**From:** dcregistration  
**Sent:** 21 May 2021 16:44  
**To:** DC Support  
**Subject:** FW: 21/01135/F - CDC Arboriculture

**From:** Iain Osenton <iain.osenton@cherwell-dc.gov.uk>  
**Sent:** 21 May 2021 14:52  
**To:** Emma Whitley <Emma.Whitley@Cherwell-DC.gov.uk>  
**Cc:** Planning <Planning@Cherwell-DC.gov.uk>; dcregistration <dcregistration@Cherwell-DC.gov.uk>  
**Subject:** 21/01135/F - CDC Arboriculture

Drawing No.  
303/2019/01A

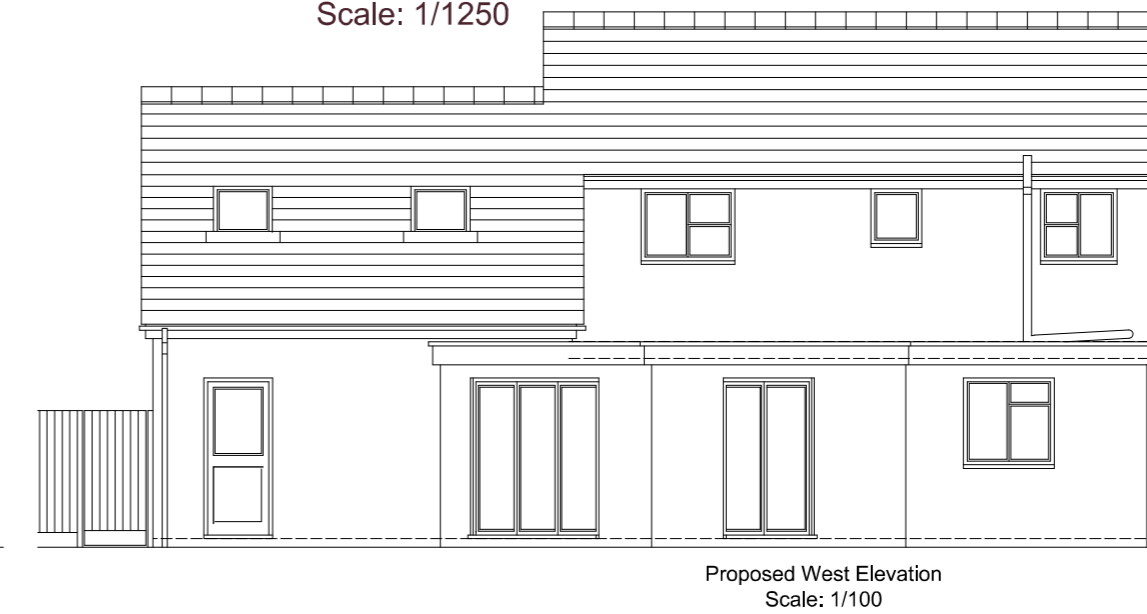
The proposal does not appear to give reference to the trees north of the existing dwelling. The proposed extension is expected to offer significant short term impact to the trees, likely requiring their removal in order to facilitate the proposal.

Confirmation is required if trees are scheduled for removal or retention, I may need further information for review following this confirmation.
